**Consultation Response from KC,
Highways Development Management****2026/91690 Land adj, 7, Tommy Lane, Linthwaite, Huddersfield, HD7 5SQ****Demolition of existing stable block and erection of detached dwelling with detached garage and associated works****Date Responded: 15 July 2026****Responding Officer: Sheila Henley****Responding Ref: K2-9/19****Recommendation: No objection.**

Plan ref: 2507-0201-P03 - Site Layout Plan Section as Proposed; Fire Appliance Tracking; 507-0202-P02 - Proposed Floor Plans Elevations.

DRAWING TITLE
FIRE APPLIANCE TRACKING

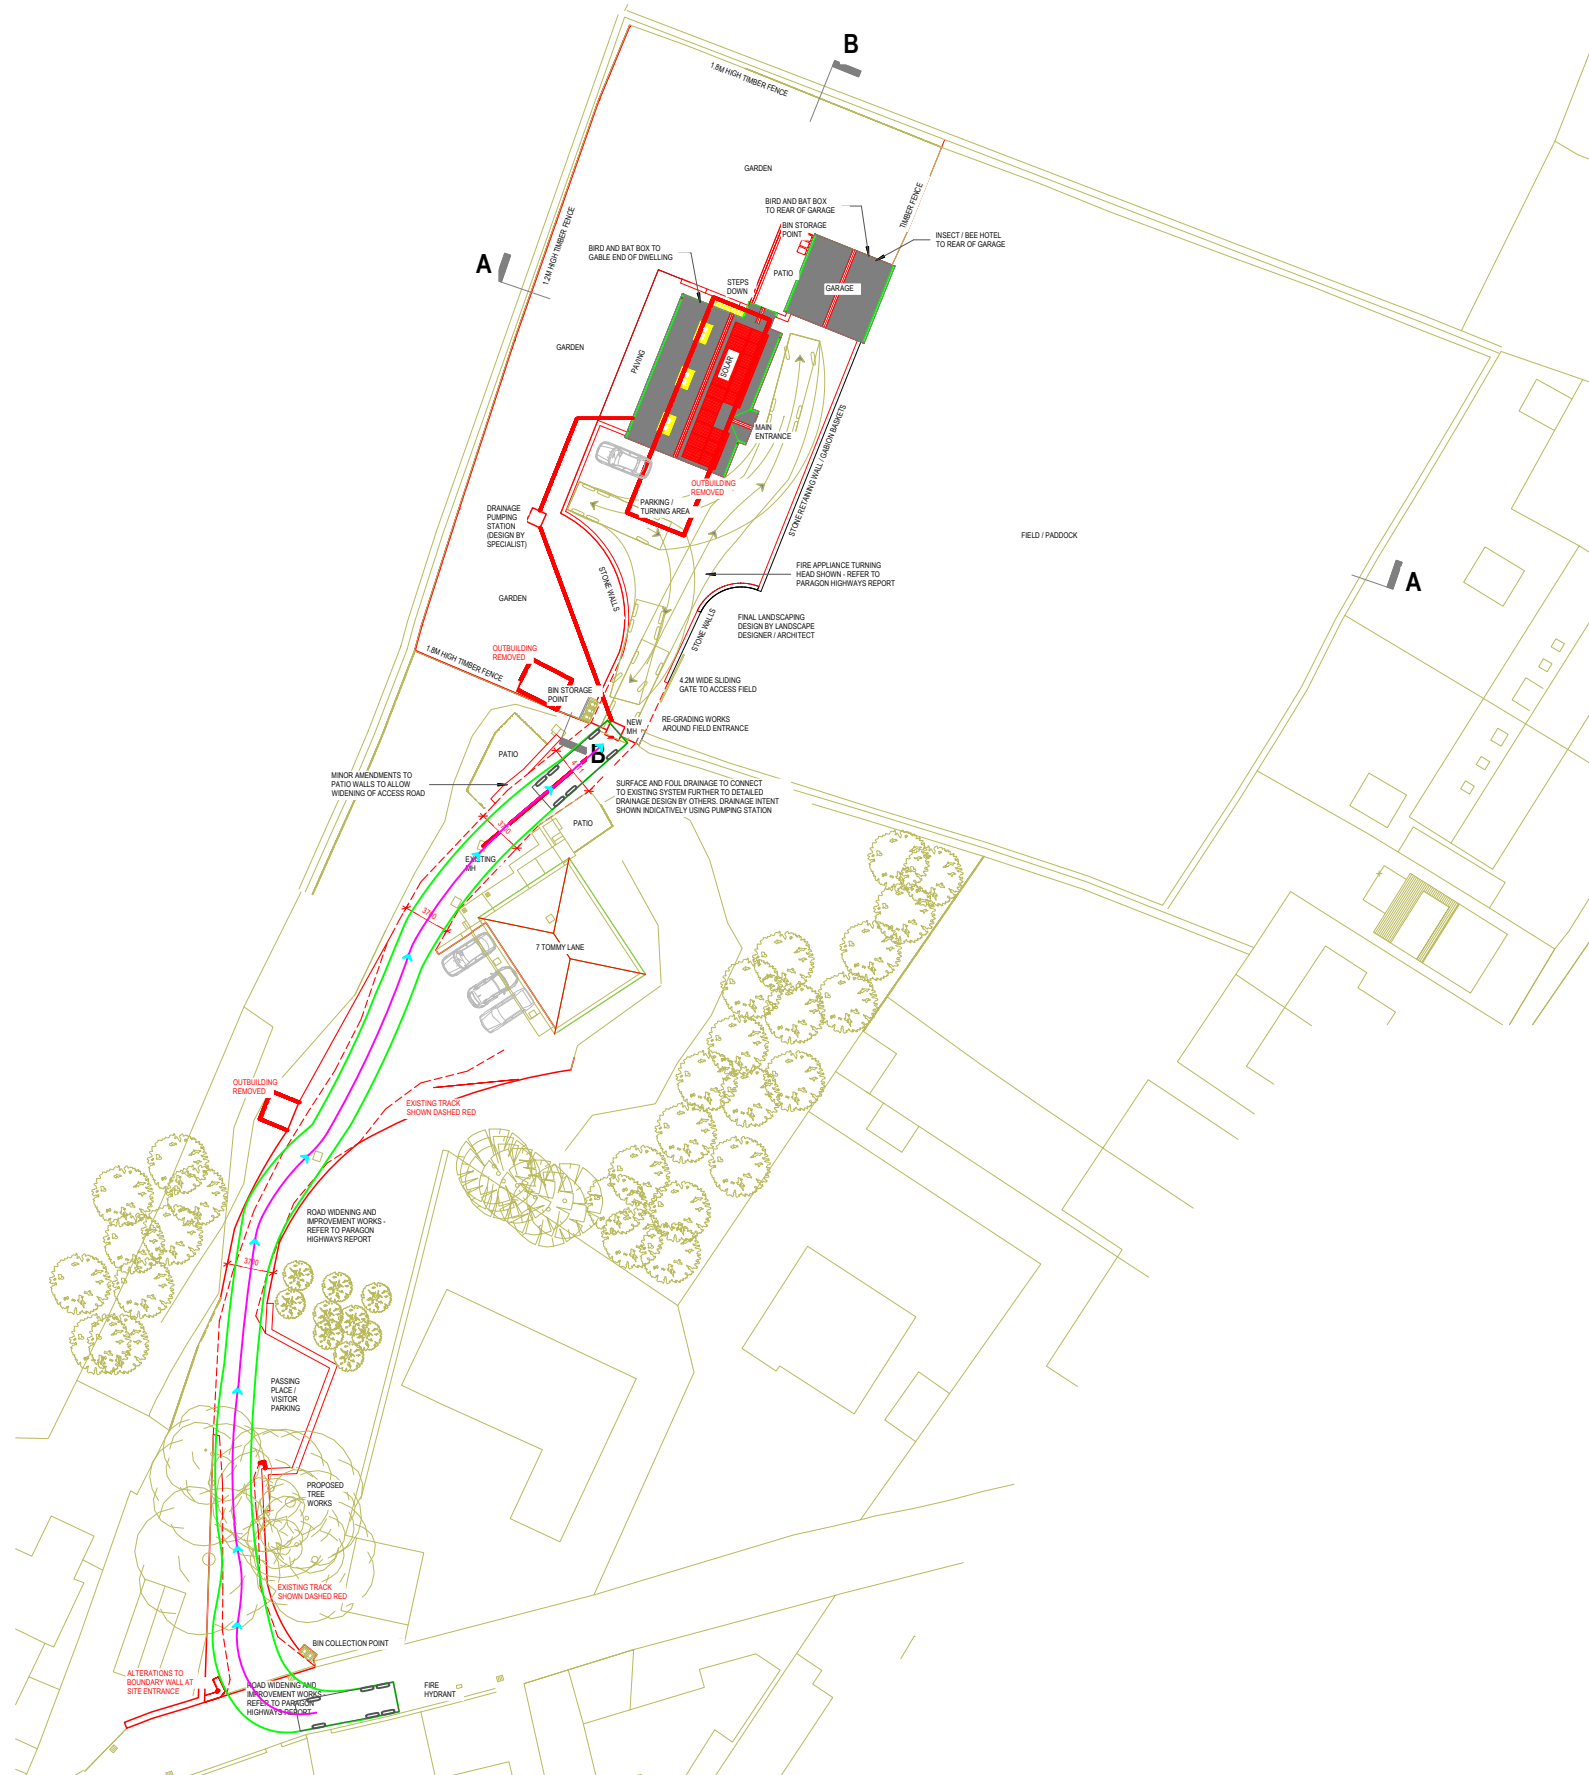
The exterior parking and turning arrangements would be suitable, including for vans, as well as fire and rescue appliance access as demonstrated by the submitted swept-path analysis indicating reverse manoeuvres within the proposed turning head to show forward gear entry and exit.
